Application No: NWP/23/00019/PREF

Proposal: Replace glazing units and external doors to all addresses, propose replacing these with UPVC double glazed windows, and composite GRP cottage style doors.

Location: 1-6 Mackworth Green, Finedon, Wellingborough

Drawing Title: Site A - Proposed Elevations - Block 01

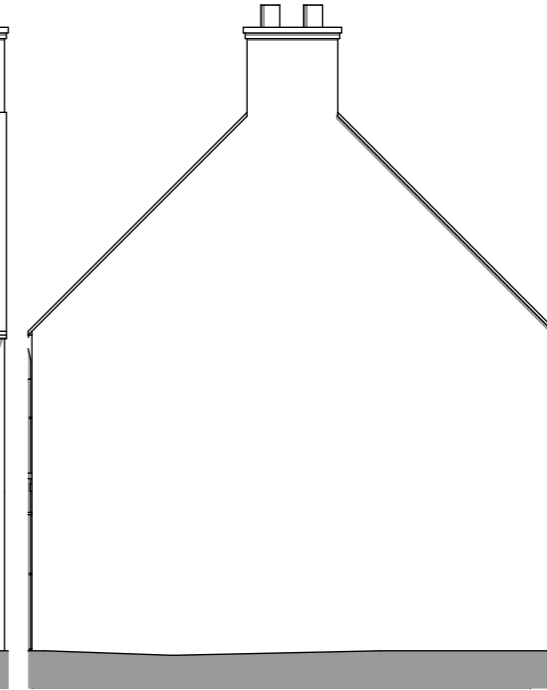
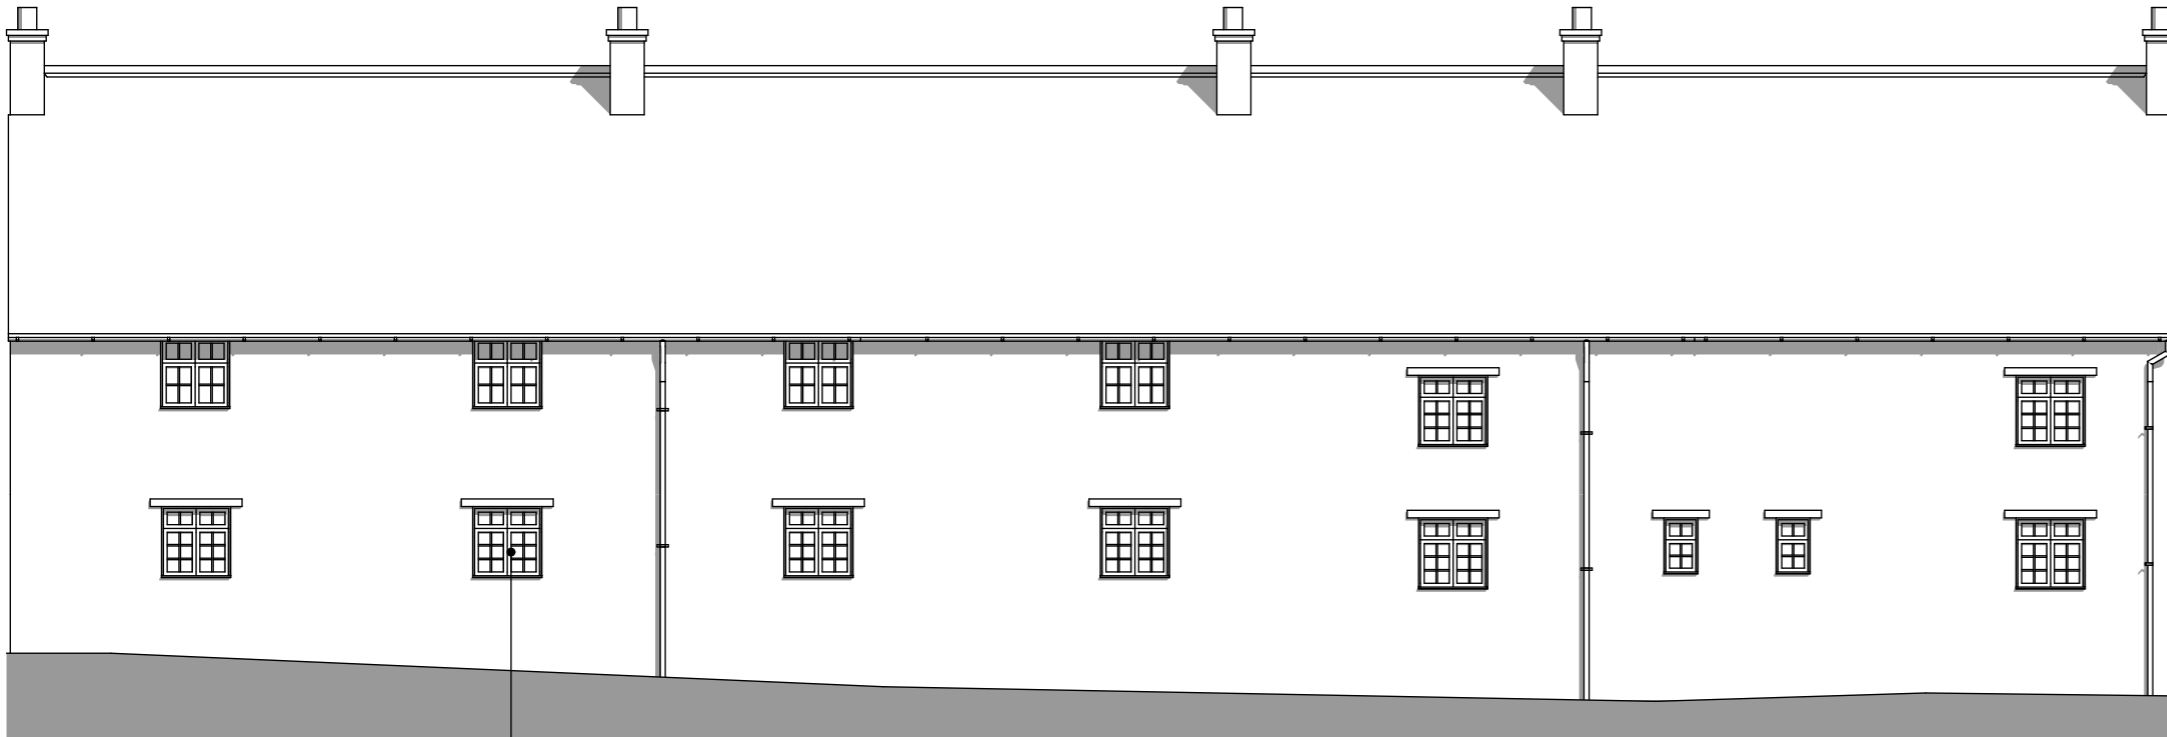
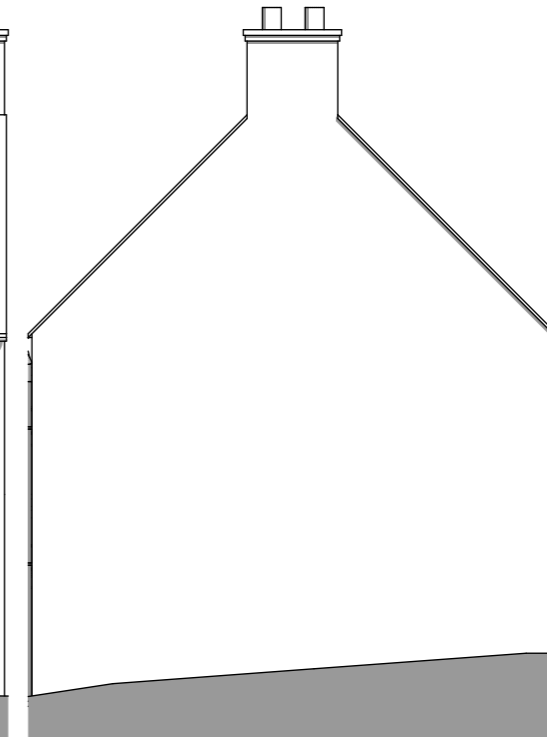
Should it be sufficiently evidenced that the windows are beyond repair, they should only be replaced on a like-for-like basis (this will include glazing type i.e. single glazing should not be replaced with double-glazing). If it is determined that the existing windows do not have any special interest, then a judgement must be made as to an appropriate replacement. However, non-traditional materials such as uPVC would be considered an unsympathetic and inappropriate introduction to designated heritage assets and traditional buildings and is unlikely to be supported. The existing cottage style doors are not considered to be of any special architectural or historic interest and, as such, the principle of replacement is established, subject to design, materiality, and external finish colour. Non-traditional materials such as uPVC or composite would be considered an unsympathetic and

inappropriate introduction to designated heritage assets and traditional buildings and is unlikely to be supported’.

Accordingly, the proposals in their present form are considered not to comply with policy 2 (a) and (b) of the JCS or the NPPF.

NNC senior built heritage consultant considers that replacement with more traditional windows and doors that better reflect the original historical character of the building a more suitable replacement.
